Ribble Valley Borough Council  
Housing & Development Control

Application no: **3/2022/0384**

Address: **11 Jeffrey Avenue Longridge Preston PR3 3TH**

Proposal: **Proposed single storey extension to the front.**

drawn	date	scale
d.h.	04/22	1:100
dwg no.		revision
<b>1489/01</b>

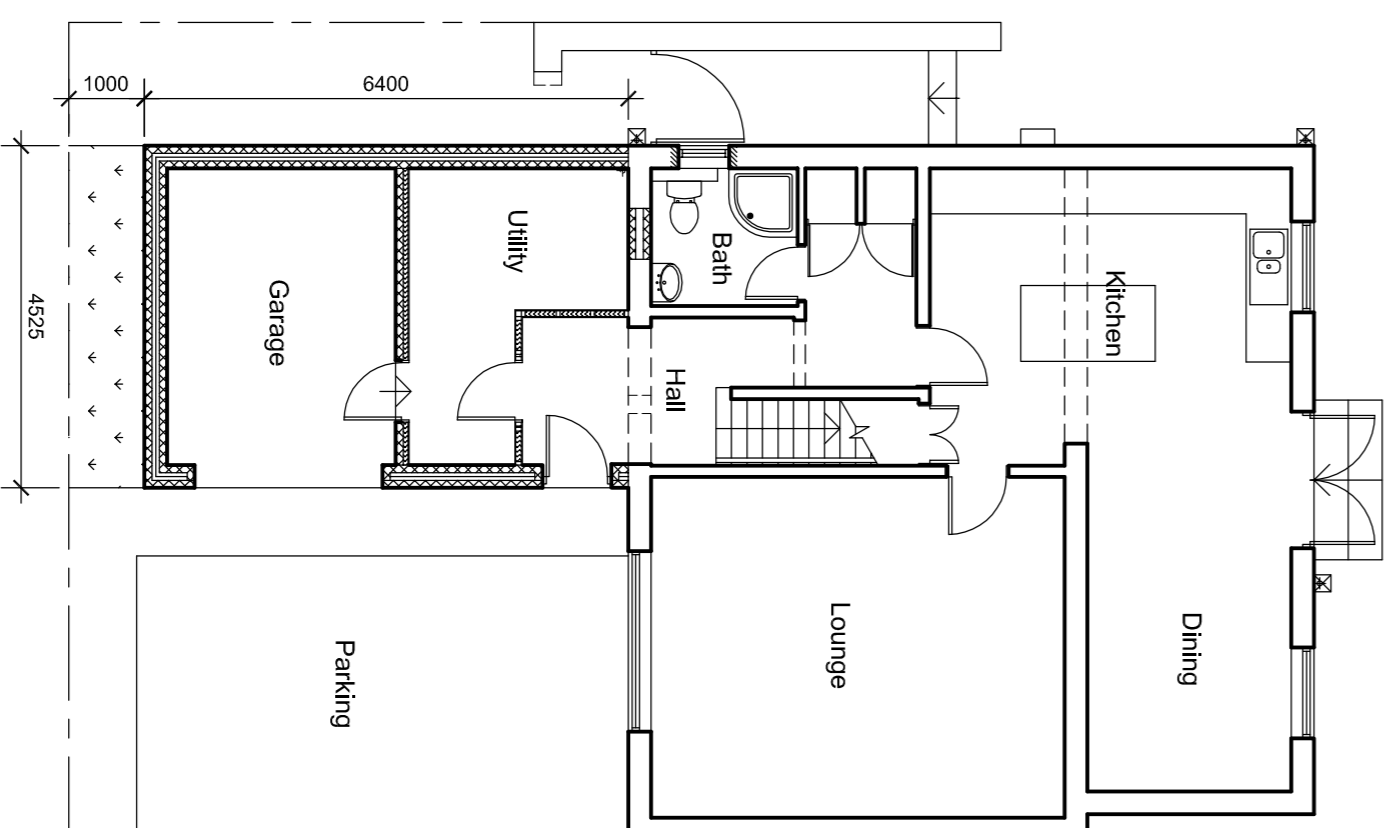
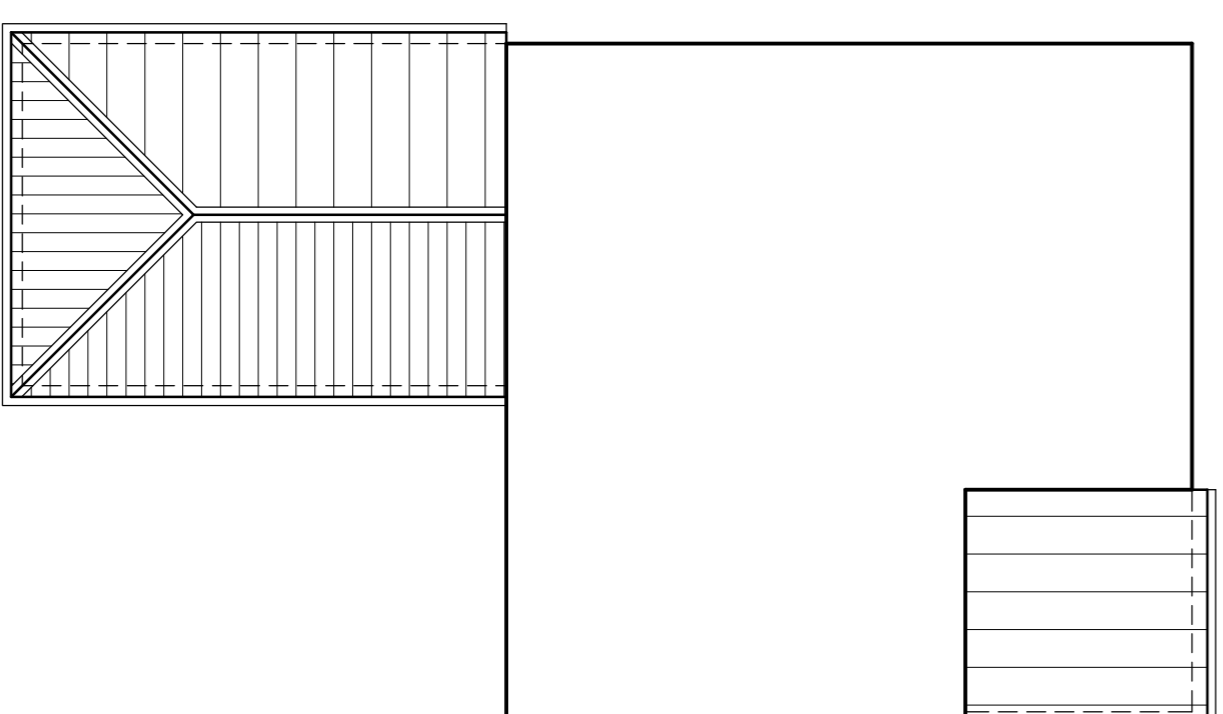
The LHA have reviewed David Haworth drawing number 1489/01 titled "Proposed Extension" and are aware that the dimensions of the garage will be 4.525m in length and approximately 3m wide. These dimensions of the garage do not comply with the LHAs guidance when providing one car parking space. This is because the LHA require the dimensions of a garage providing one car parking space to be a minimum of 6m in length and 3m wide. Therefore, there is a shortfall of 1.475m in the minimum guidance.

The LHA require the length of a garage providing one car parking space to be a minimum of 6m to ensure that the garage is an adequate length for a vehicle to use it as a car parking space. Therefore, when there is a significant shortfall in the length of a garage, like the one proposed, the LHA question the usability of the garage and so will not accept the shortfall.

Not only this but even if the LHA accept the shortfall in the dimensions of the single garage, the LHA question how vehicles will be able to access it. This is because the garage doors are located facing away from the public highway, meaning that vehicles will have to turn onto the existing driveway to access the garage. However, there is limited space on the existing driveway between the proposed garage and the neighbouring dwellings hedge, with there being a space of 4.5m. Therefore, the LHA are concerned that this space isn't long enough for a vehicle to use while the garage doors are being operated. This could cause vehicles using the garage to wait on the adopted highway which could be detriment to highway safety.

The limited space between the garage and the neighbouring dwellings hedge could also prevent longer vehicles from accessing the garage fully, which would make the garage redundant as a car parking space.

Therefore, as a result of the dimensions of the garage not complying with the LHAs guidance and the existing driveway only being able to provide one car parking space, there is a shortfall of two car parking spaces at the site.

The LHA deem that the shortfall of two car parking spaces would lead to inappropriate parking occurring within the vicinity of the site. This would be to the detriment of highway safety which in turn is contrary to paragraph 111 of the National Planning Policy Framework (2021). Therefore, the LHA object to the application.
